6875 JUANITA ST parcel 52082-24-010
 PLAT 871 ZONE RR-5 lot 22263 SQFT

SFD2118711

APPROVED
 Plan Review

SFD211871
PLAT 871
REF MER166
RR-5

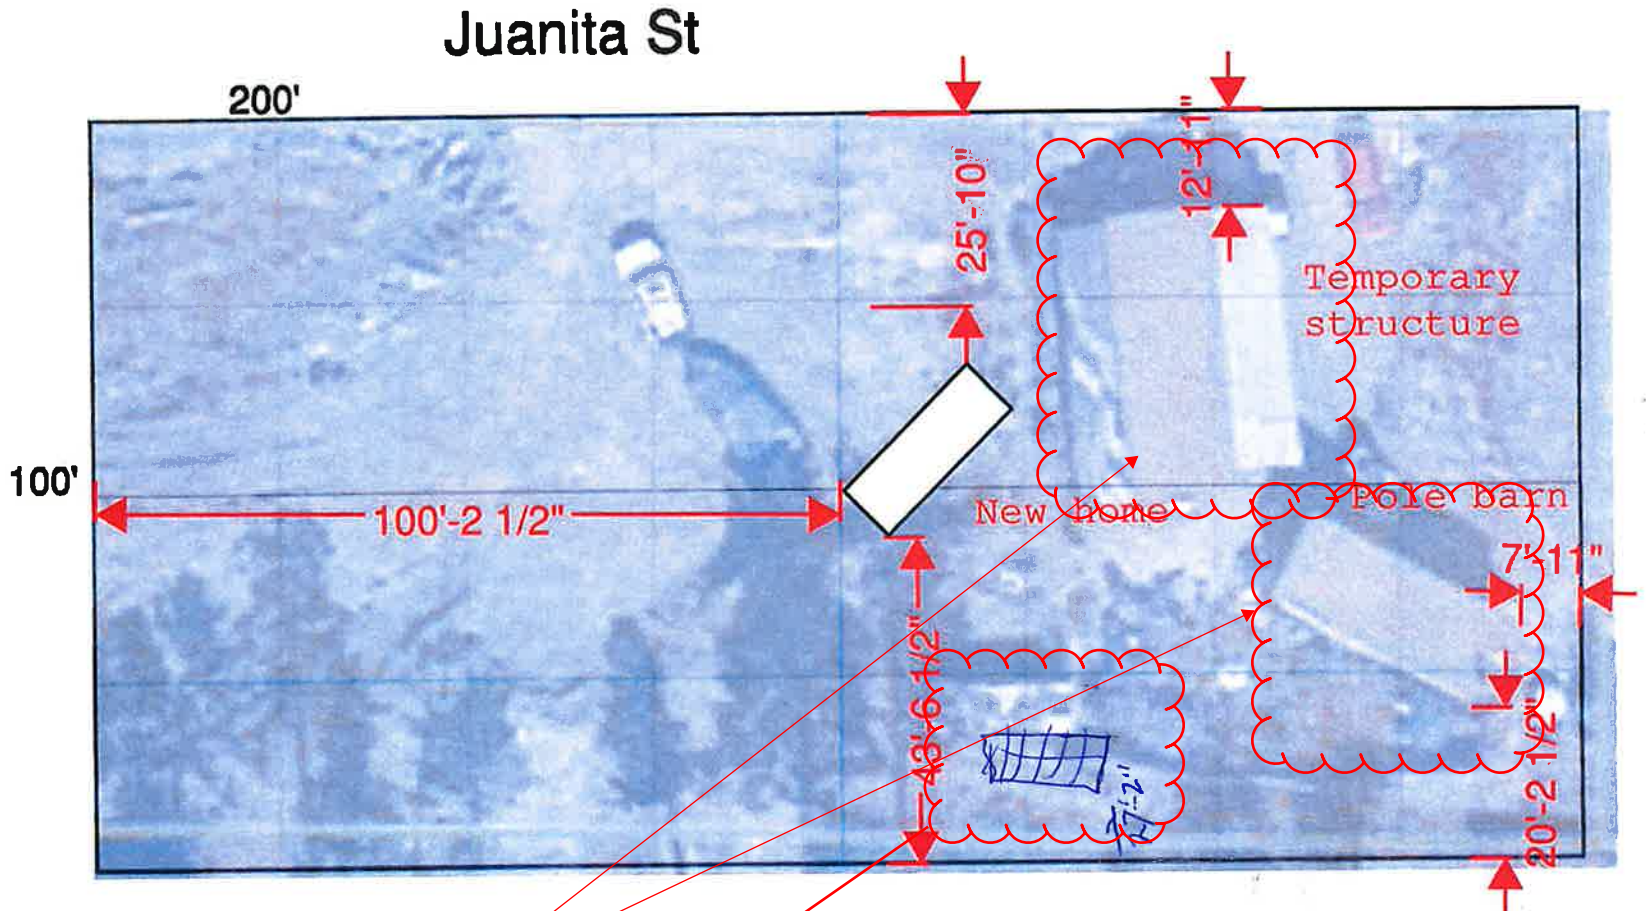
All three accessory structures must be either removed or the applicant must submit for a Board of Adjustment for the encroachments. The CO will be held on the home until they are removed or approved by the BOA.
